From: Amanda Scholes on behalf of Planning.Responses
Sent: 21 December 2021 08:24
To: Planning Scanning
Subject: FW: FG/183/21/HH - 52 Ocean Drive - LACK OF FRA

From: Amy Myer
Sent: 20 December 2021 21:04
To: 'Glenn Curran'
Cc: 'Mark and Louise Wood'
Subject: RE: FG/183/21/HH - 52 Ocean Drive - LACK OF FRA

I will shortly be submitting a new planning application which will show amended dormers to the east and north elevations.

Elevations
as Proposed

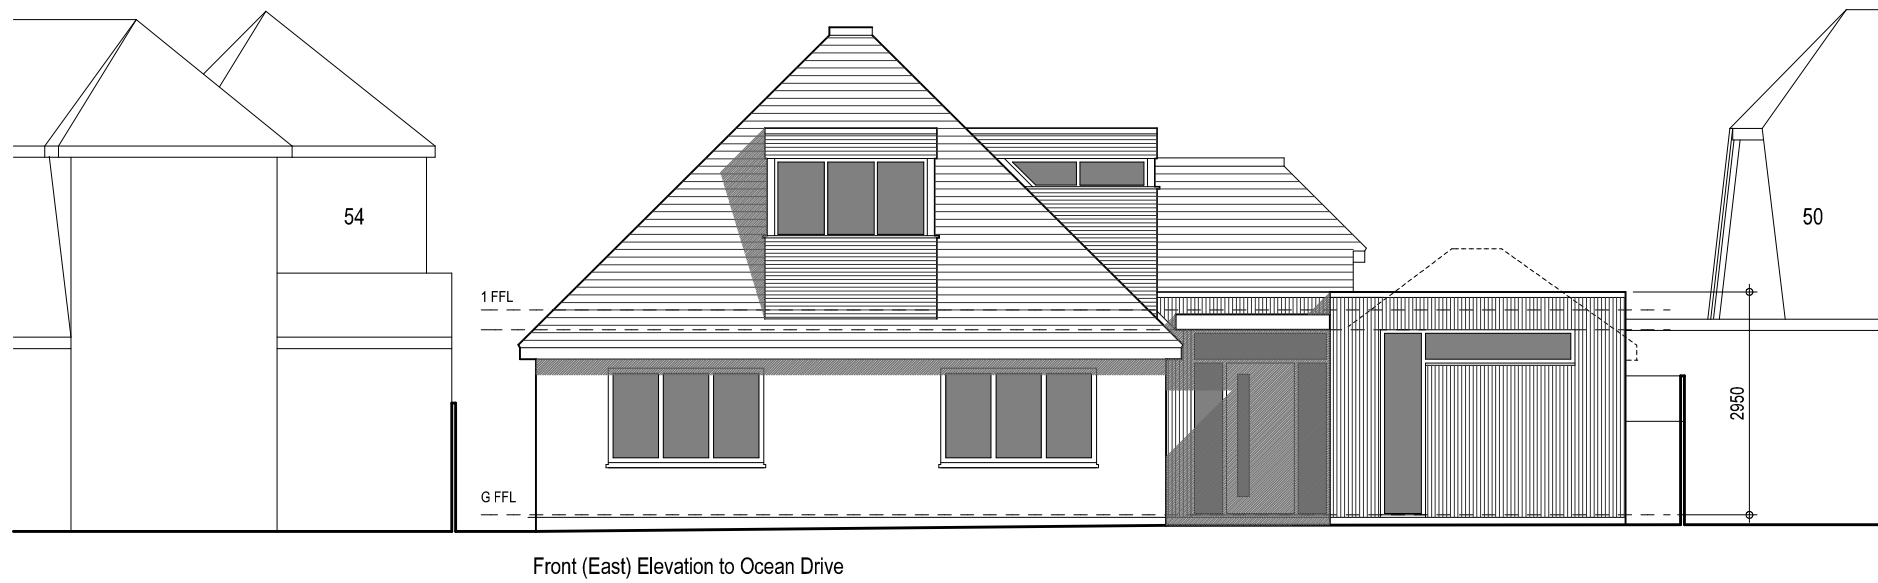
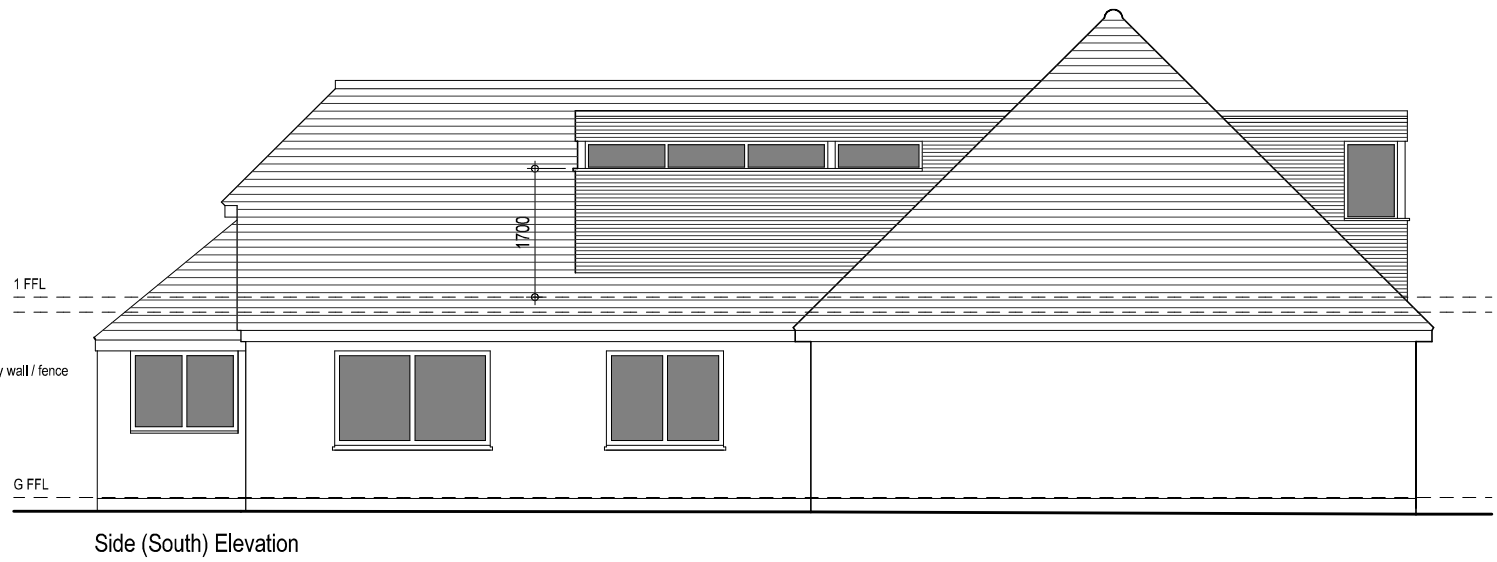
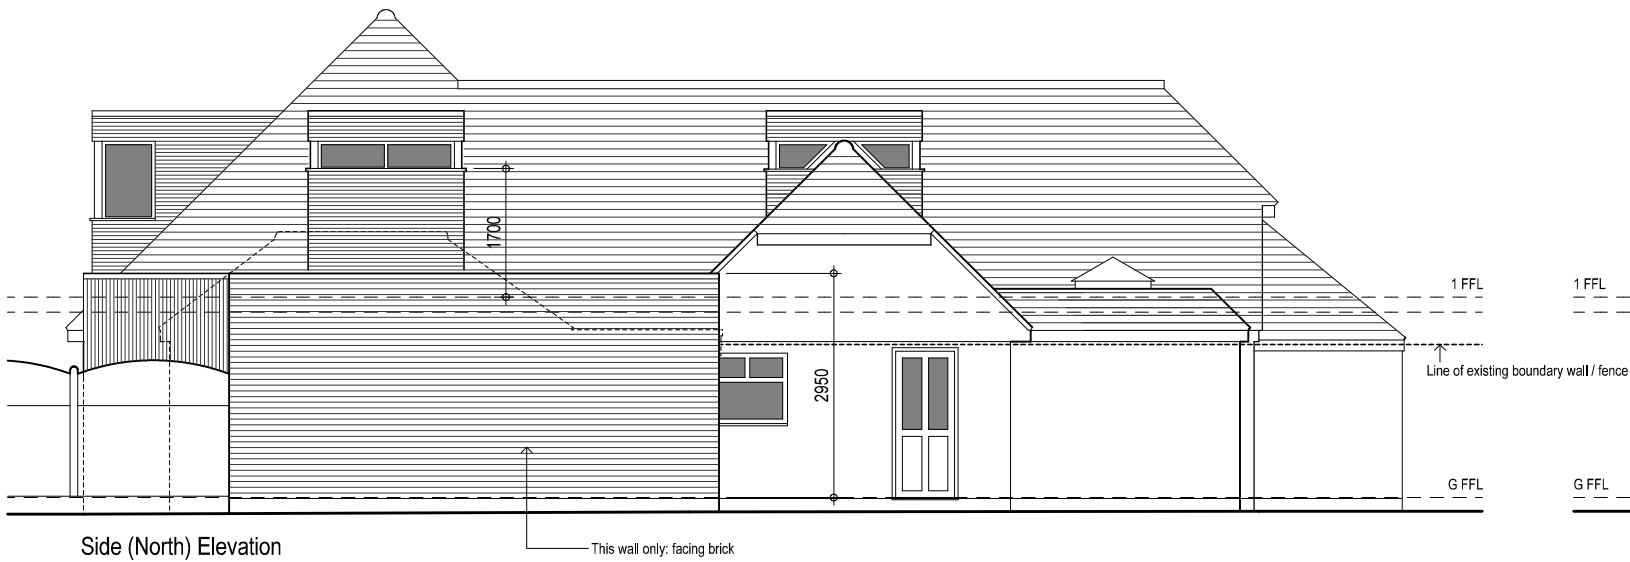
As such, without an FRA and EA consultation, we would unfortunately have to recommend refusal of the current application. In addition, I have concerns that the front dormer is overly bulky i.e. the flat roof and window part may be OK but that the underneath part extends too far down appearing unnecessarily bulky and not subordinate in the roof i.e. should stop short just under the lower window sill. The side dormer on the northern elevation equally should be set further up from the eaves. I also wonder if these could be designed with pitched roof forms instead to have a more charming appearance than 'boxes'. These should appear as small proportional additions which do not dominate the roof form, given the existing roof scape along this area and modest small dormers.

I would suggest you therefore withdraw the current application and re-submit with an FRA and revised drawing to address the visual impacts of the dormers.

Further to my email below, I discussed it with the East Team Leader and they agreed with my advice re the dormers previous design being overly bulky etc. and we agree the revised design is now acceptable.

Although I can't agree with the observations made regarding the dormers, I have produced a revised scheme which shows a significant reduction in the bulk of the dormers to the east and north elevations. Drawings attached.
